**North Byron Parklands Cultural Events Site (SSD 8169 and MP 09_0028 MOD 3)
Comment on the Environmental Impact Statement**

16 February 2018

**North Byron Parklands Cultural Events Site (SSD 8169 and MP 09_0028 MOD 3)
Detailed comment on the Environmental Impact Statement**

SHEET NUMBER	3 OF 21
REVISION	A
PROJECT NUMBER	B17/016 P

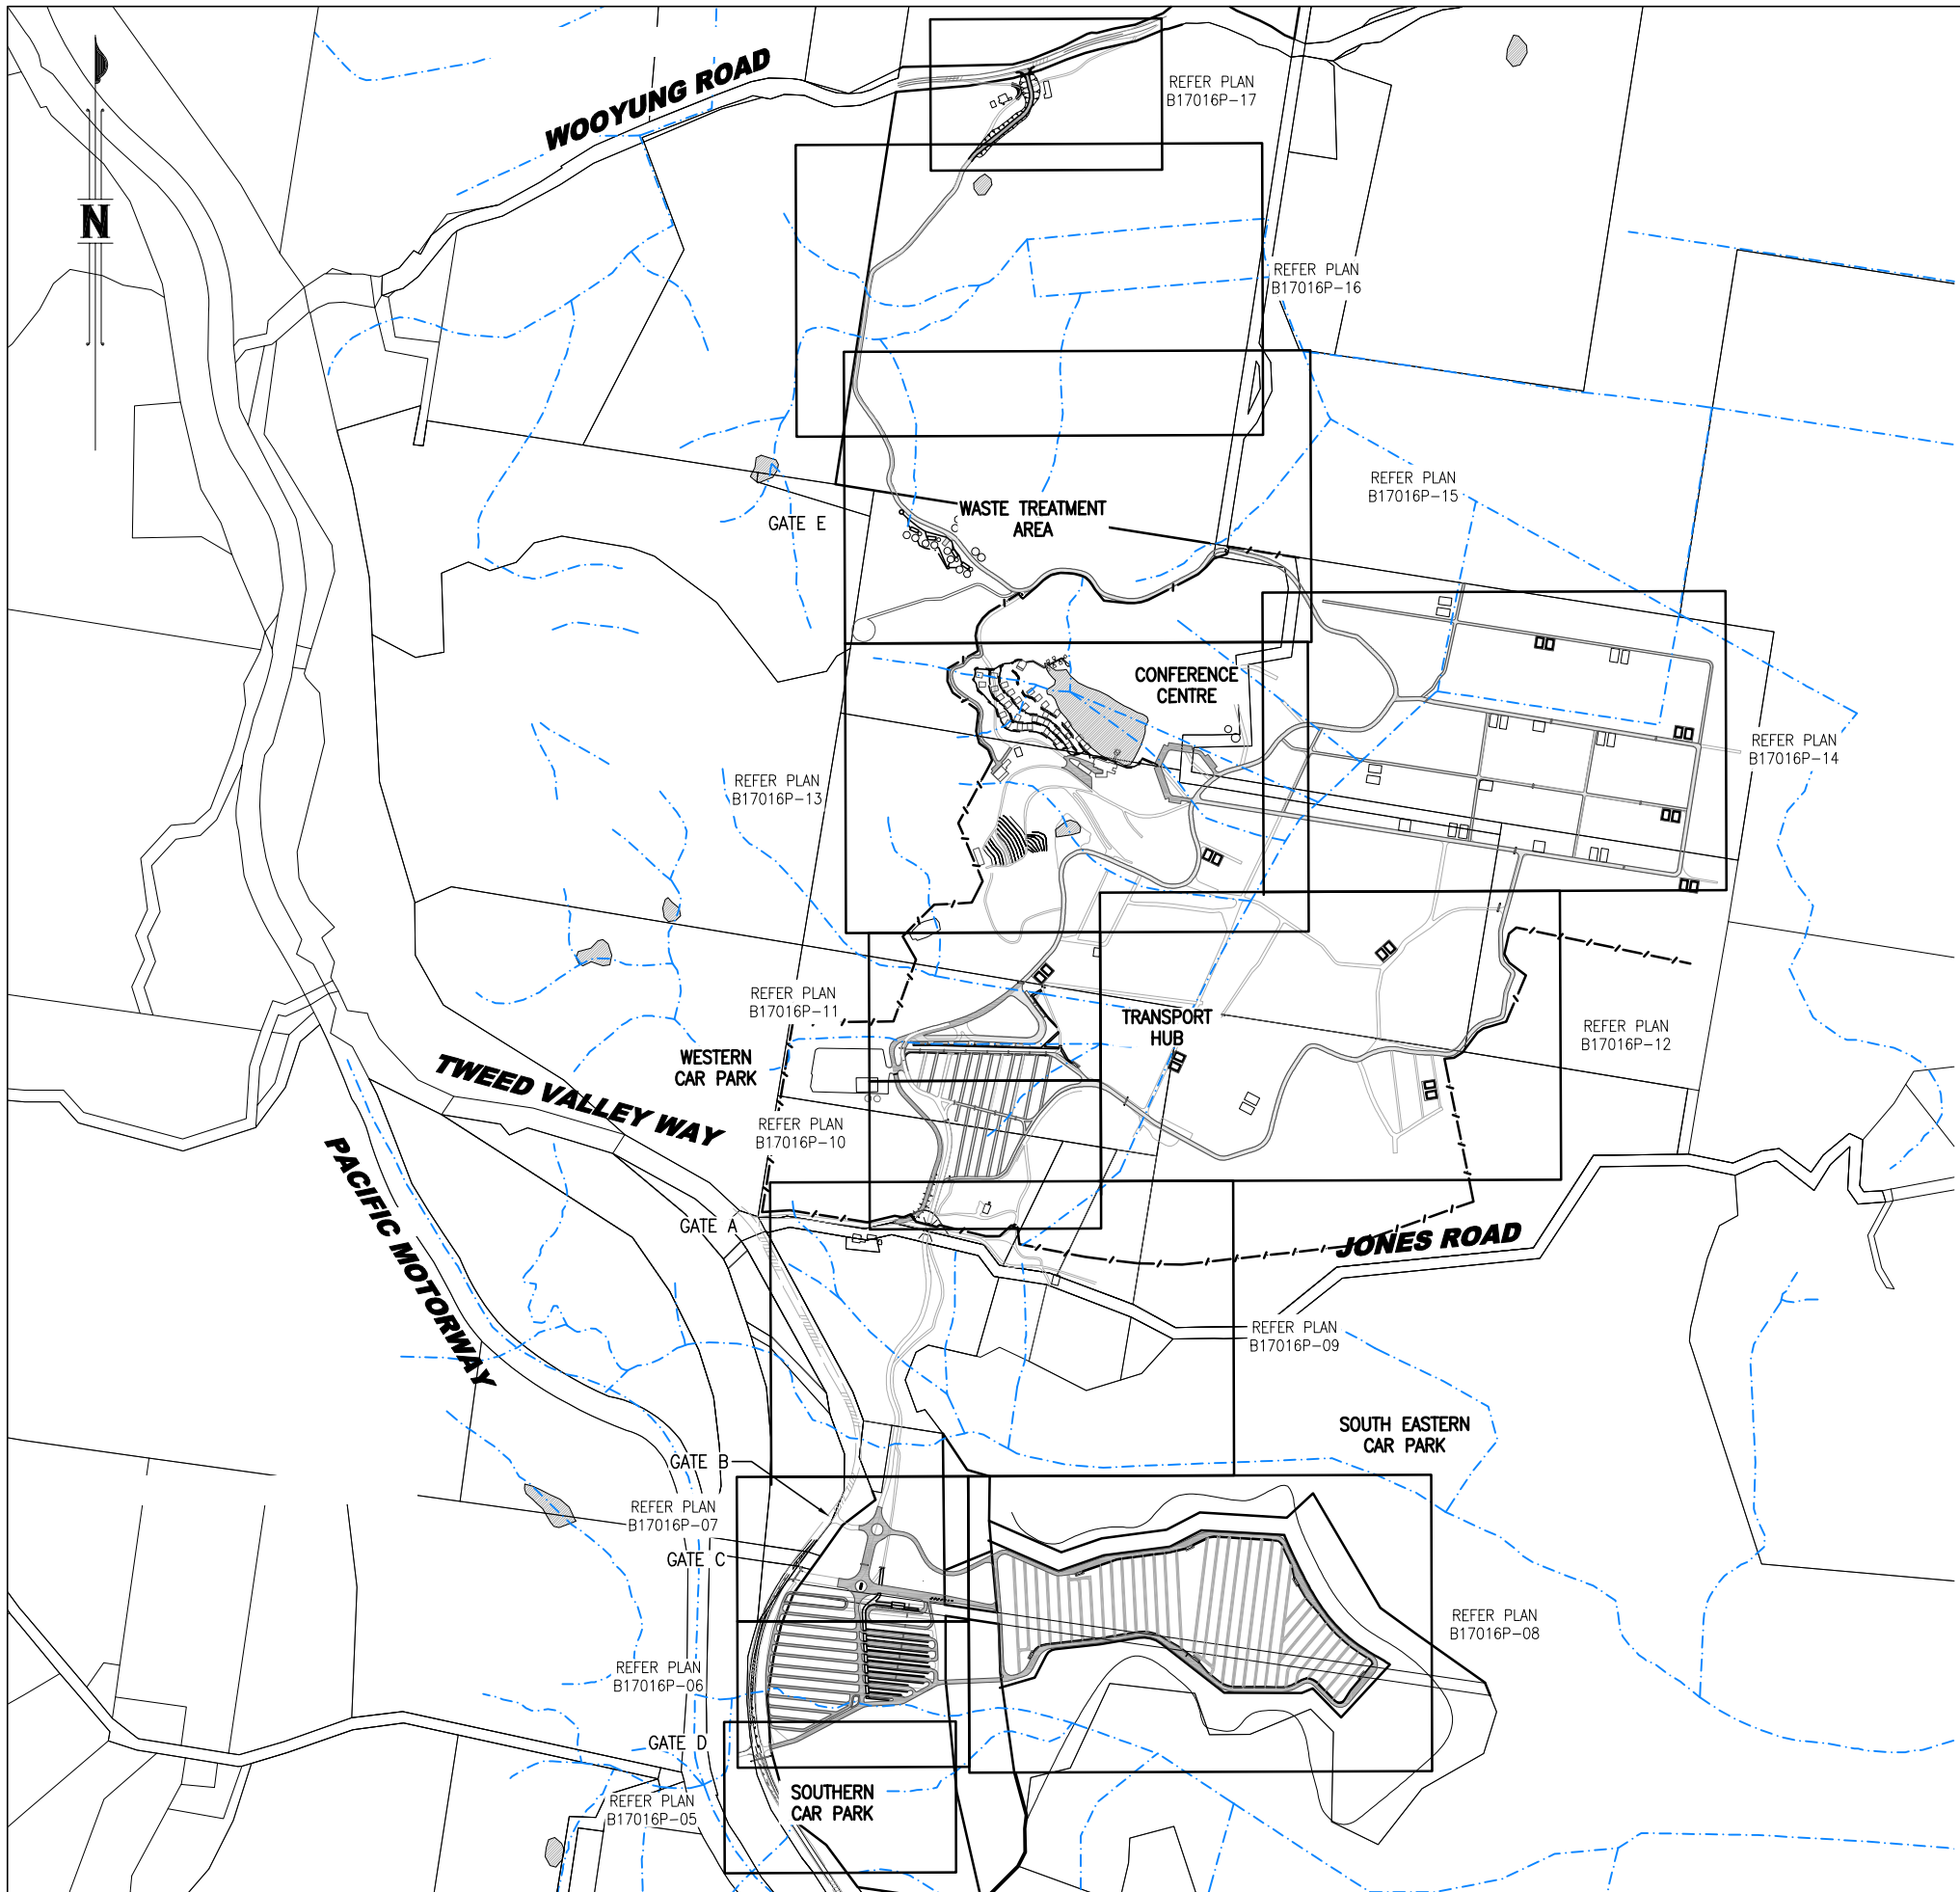
- Some works (e.g. cabins, amenities buildings, roads and road upgrades, carparks) are proposed on waterfront land. No or minimal buffers are proposed between (i) the top bank of Yelgun Creek and the road (near the south west car park), (ii) structures and the top water level of the existing dam near the conference centre, (iii) the conference centre car park below the existing dam and the 2nd order stream, and (iv) proposed amenities near an existing bus stop (at western carpark) and a watercourse. Vegetated buffers are required at these locations to maintain bank stability and protect water quality.

- The proposed structures around the conference centre will all be above the 100 year ARI event level.

2. A commitment from the proponent to implement a 20 metre vegetated buffer between Yelgun Creek (3rd order stream) and road near south west carpark, and 10 metre buffers between (i) proposed structures and the top water level of the existing dam near the conference centre, (ii) conference centre car park and 2nd order stream, and (iii) proposed amenities near existing bus stop (at western car park) and the top bank of the nearby watercourse.

Figure 4 South East Carpark Proposal - Layout

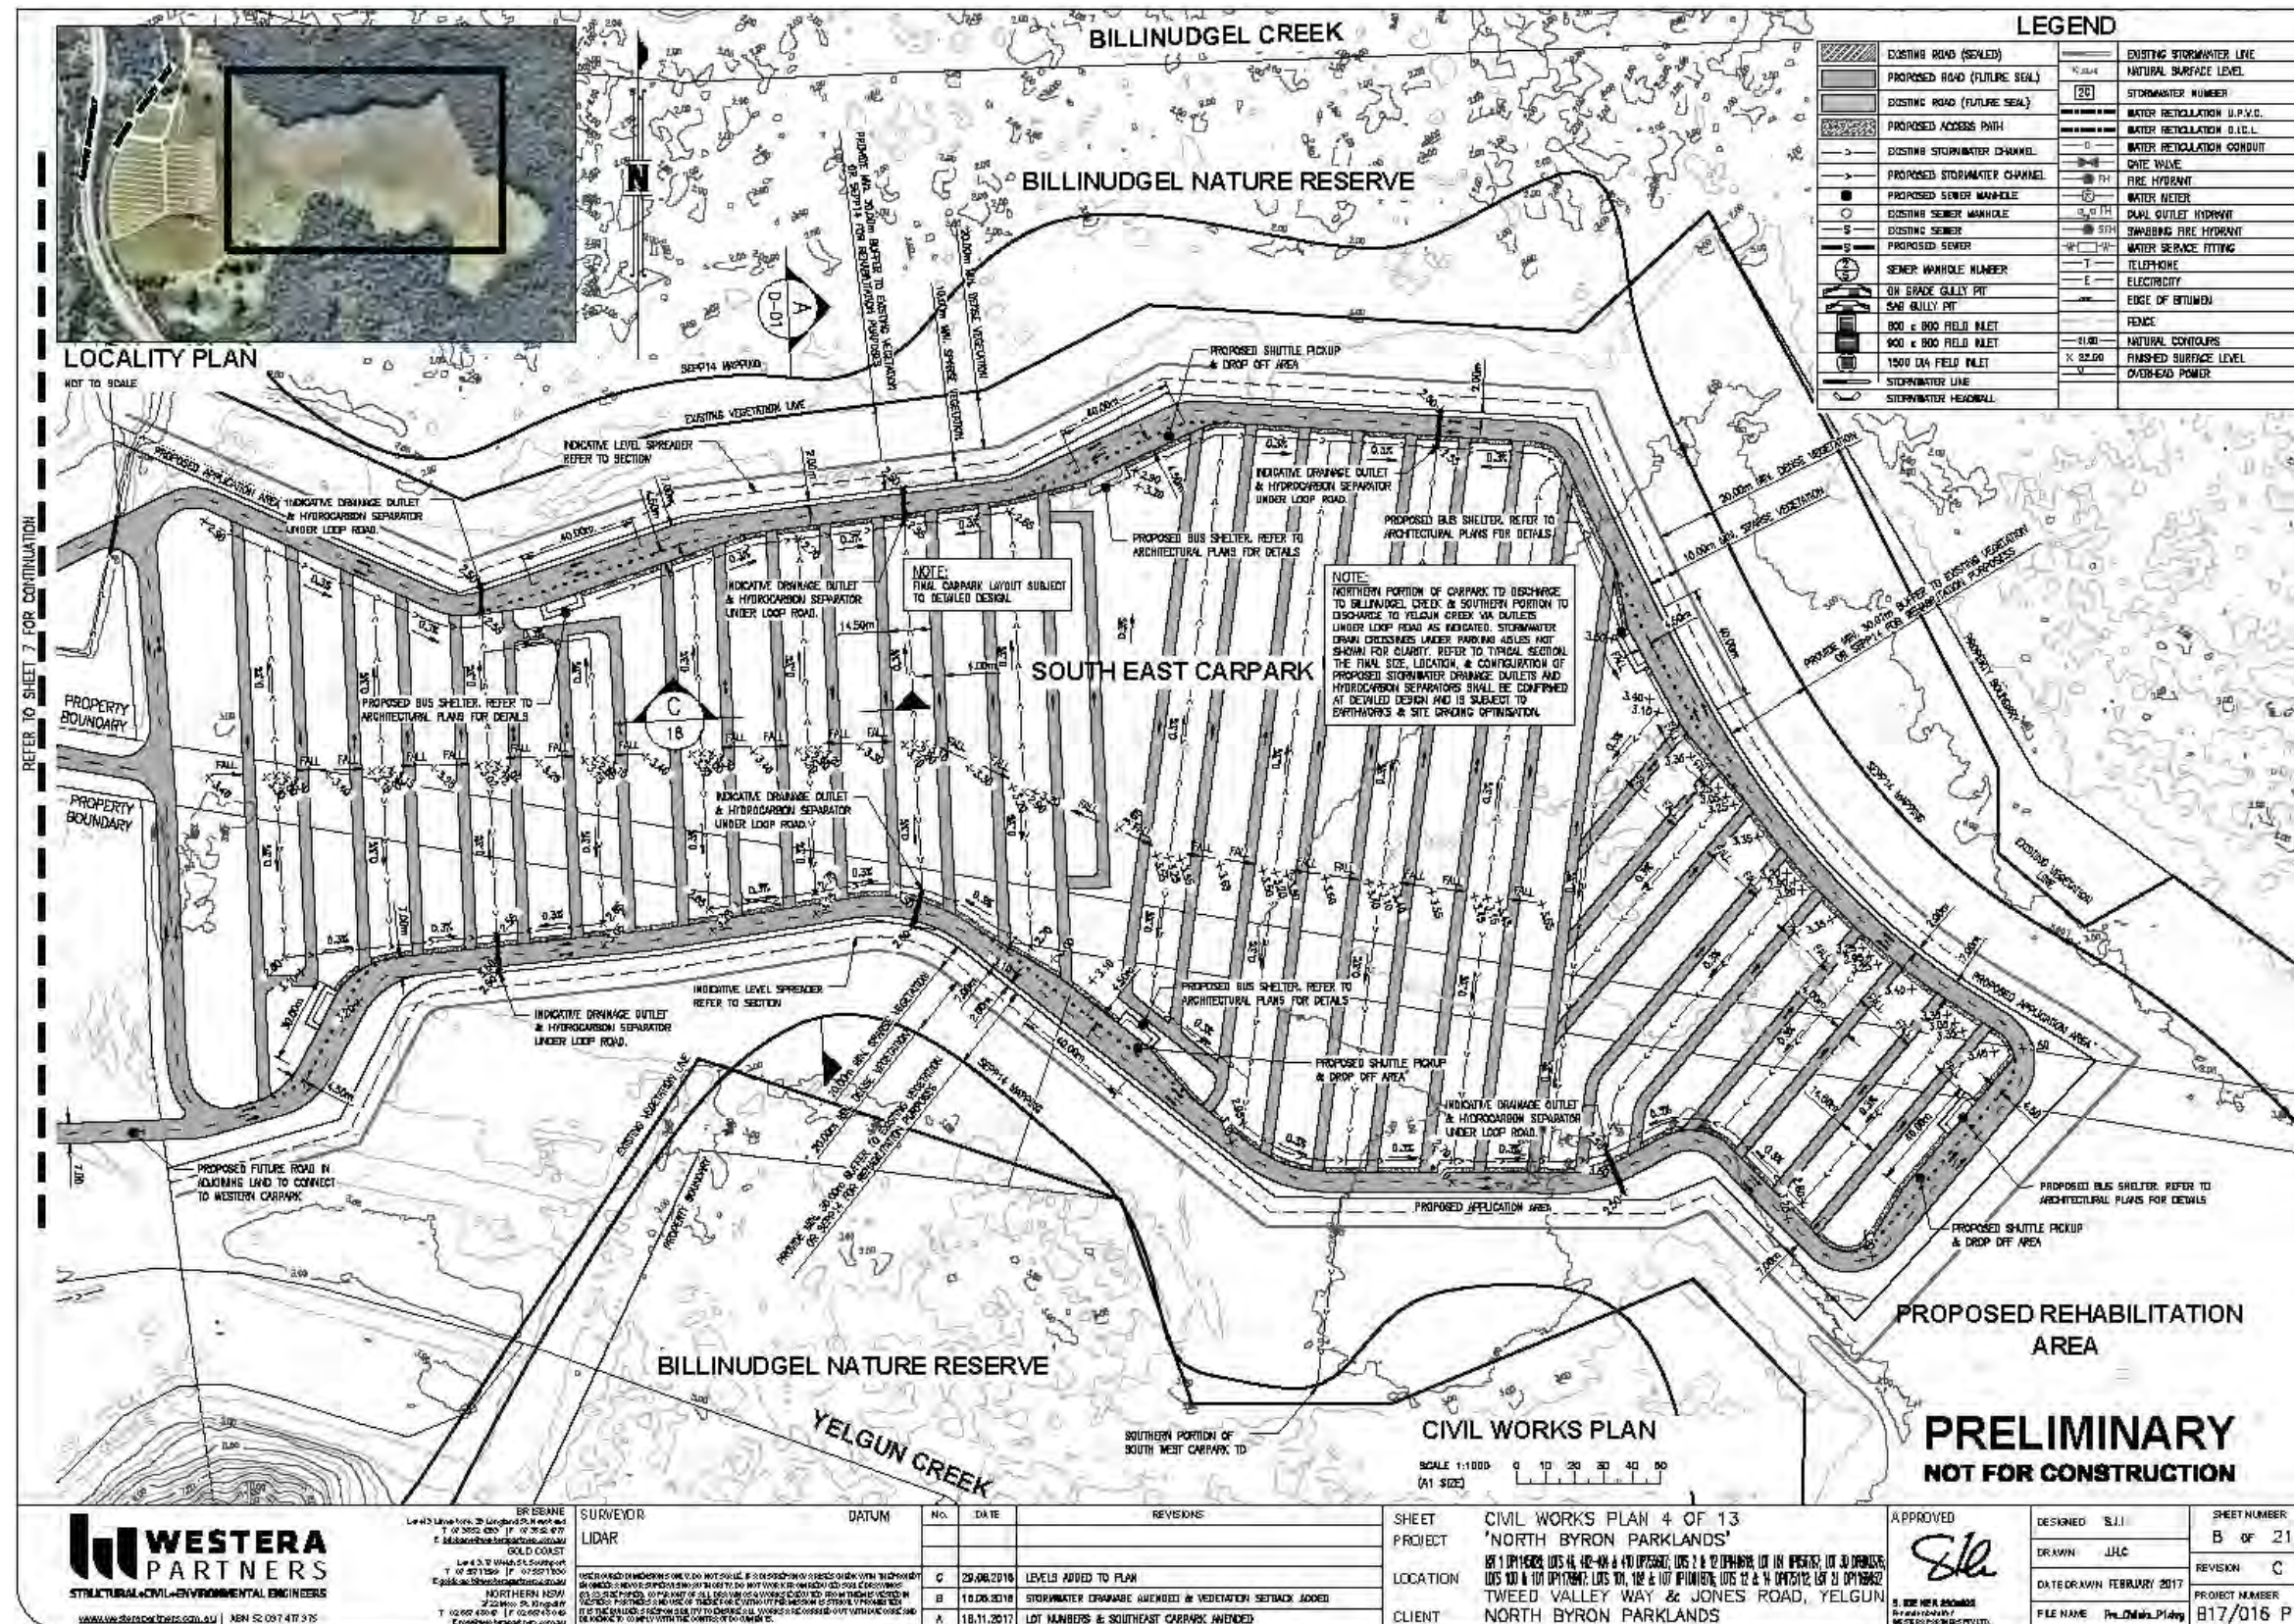
- The road connecting the northern part of the site with Wooyung Road will be upgraded (raised) to be entirely above the 100 year ARI event. Event service roads will be formed and compacted with 400mm of gravel. Additional access roads will be raised 100-200mm. A pedestrian walkway connecting event areas and the southern carpark will be raised above the 100 year ARI event level. The impacts of road construction activities on flood flows and associated impacts on waterfront land and neighbouring landholders have not been described.

4. An assessment of the impacts of proposed road construction on flood flows and associated impacts on waterfront land and neighbouring properties.
5. It is recommended that a Land Use Conflict Risk Assessment be undertaken to adequately assess any risk to neighbouring agricultural activities and resources including the provision of adequate land use conflict risk mitigation measures as appropriate, e.g. buffers. The Land Use Conflict Risk Assessment Guide is available at: <https://www.dpi.nsw.gov.au/agriculture/lup/development-assessment2/lucra>
